Subject: DM/23/02606/RM ntegra 61 - Tesla Unit - Invalid Application [LICH-DMS.FID435472]

1. Please confirm you have no objection to the following amended description: 'Reserved matters pursuant to outline planning DM/15/03912/OUT as amended by application DM/18/01597/VOC, comprising Access, Appearance, landscaping, Layout and Scale, for a proposed hardstanding car-park with ancillary features including EV charging points, substation and electrical infrastructure for Phase 6a., Intergra61'.

DRAWING:  
Surfacing detail

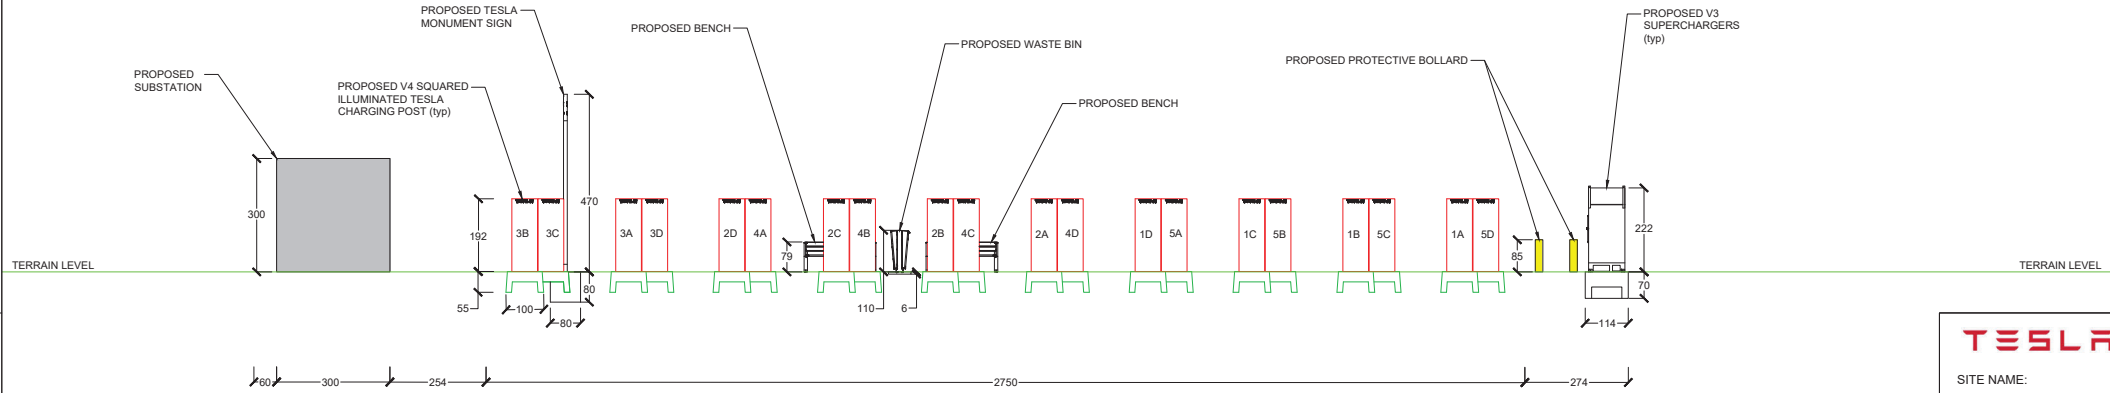
4. The extent of surfacing information submitted is restricted, relevant for the appearance of the facility: tarmac is proposed for the bays, and the vehicular movement areas in front of them. The site entrance, the periferal areas outside the bay, and the undefined area adjacent the site entrance all appear to be lacking detail.

Surfacing plan included within the attached pack of plans.

DRAWING:  
CD30 - Site elevation looking north and west

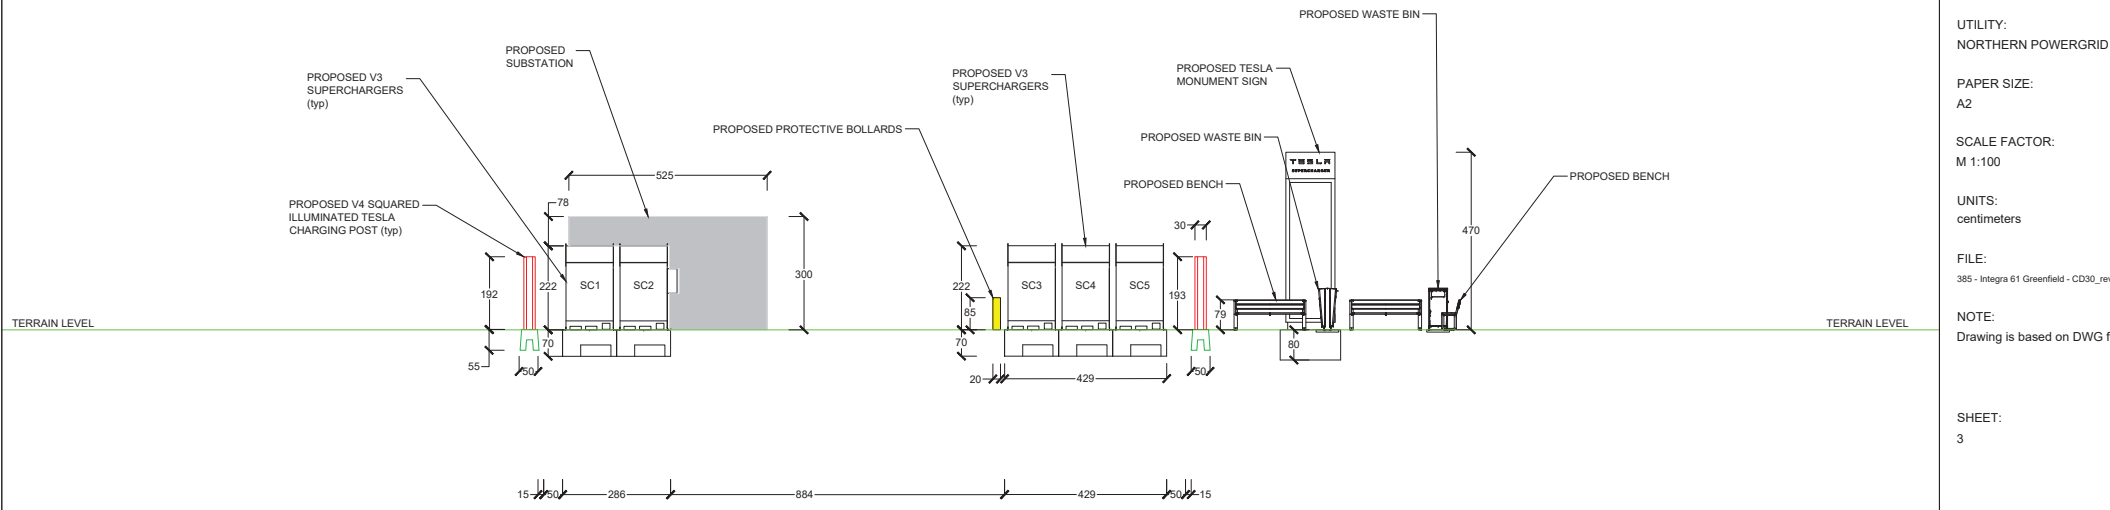
3. The application seeks approval for ancillary features including but not restricted to the proposed charging units. The submitted plan pack contains a significant amount of superfluous information not relevant to the planning application, and includes other elements on plans without explanation, for example adjacent the site entrance. A set of planning drawings should be submitted showing relevant features only, in plan and elevation.

Updated pack of planning drawings attached including site overview, layout, surfacing details, and elevations.

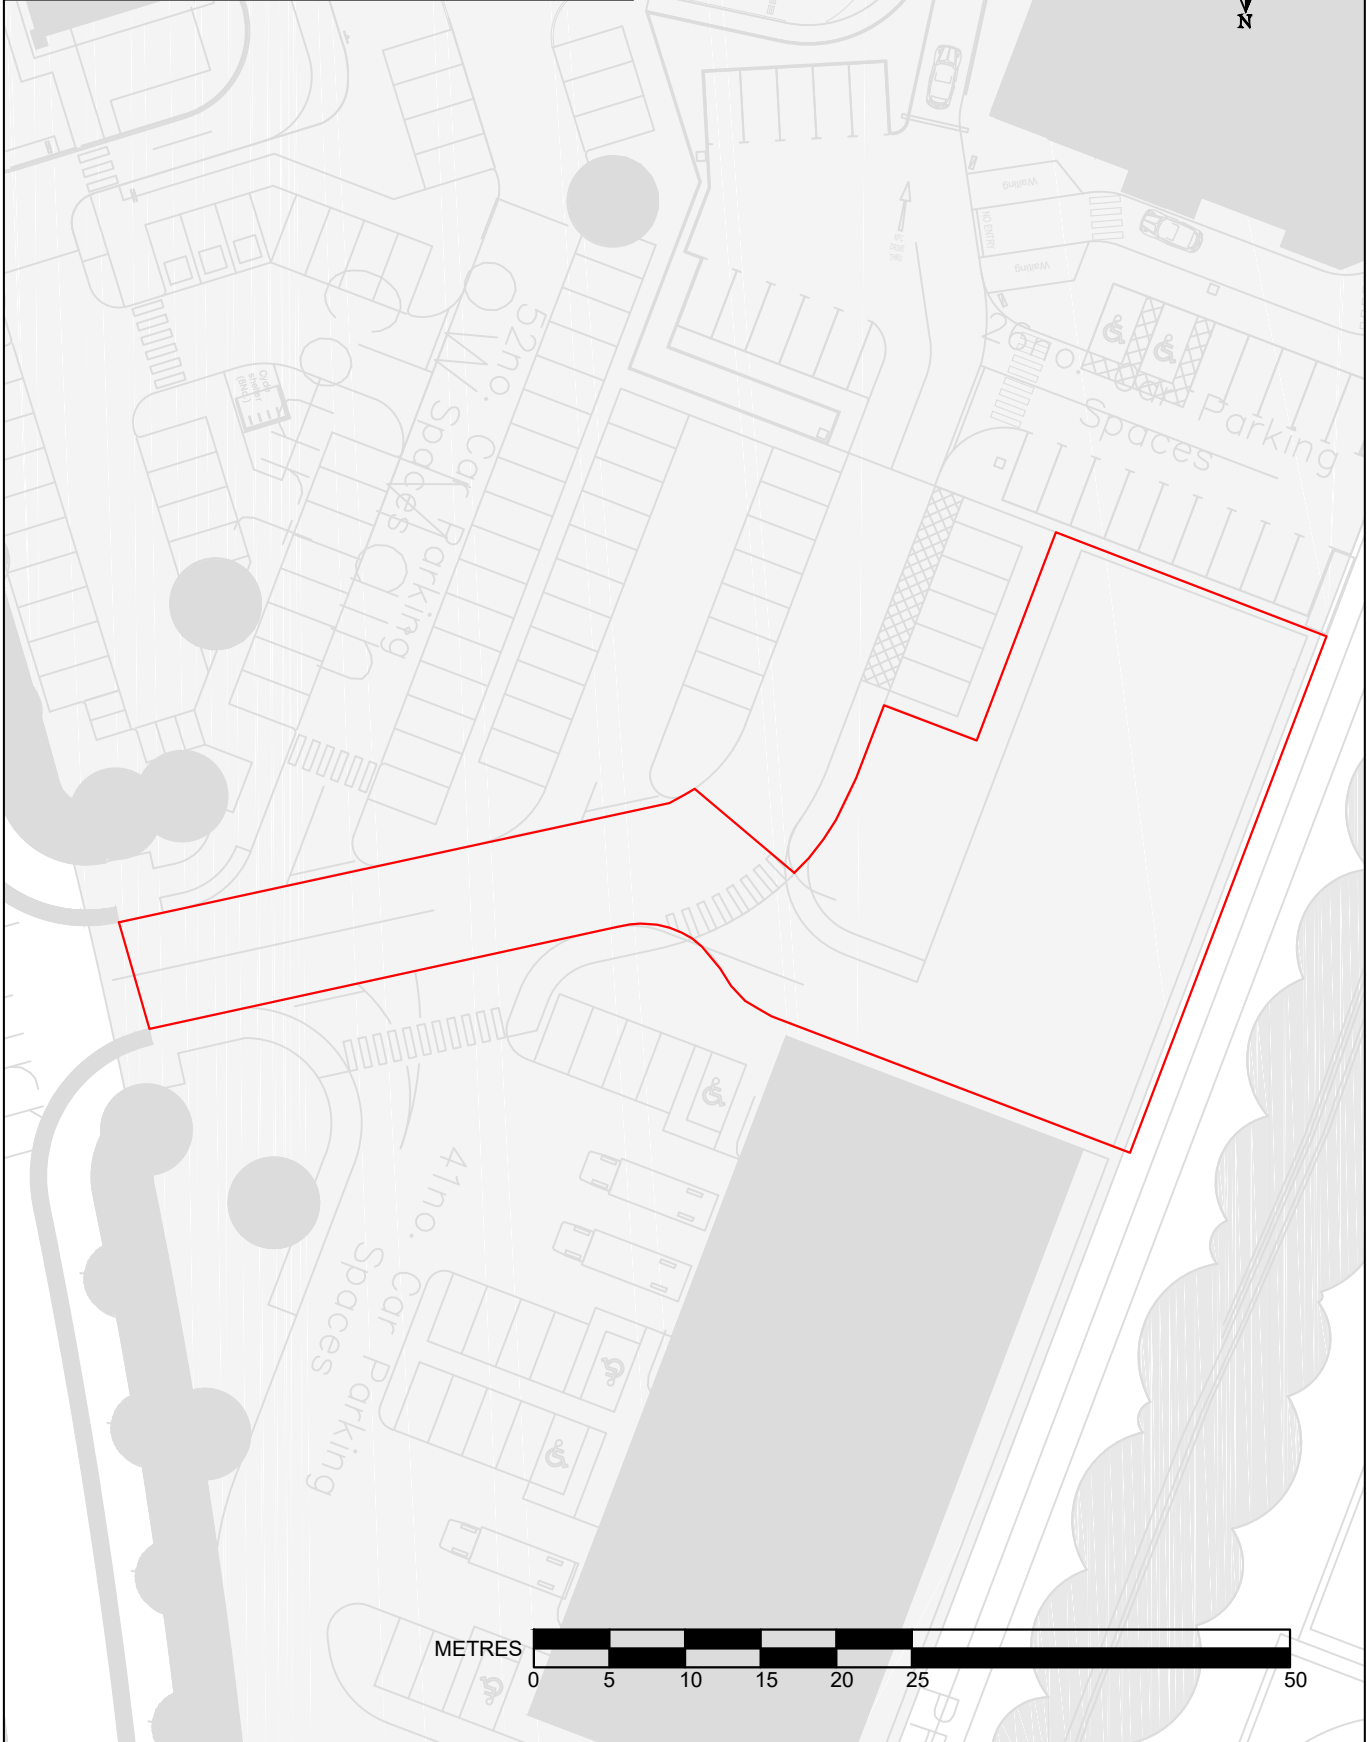
2. The red-lined boundary defining the extent of the development site must be extended to connect to the adopted highway.

The attached redline lease plans shows the redline boundary extending to the end of the development.
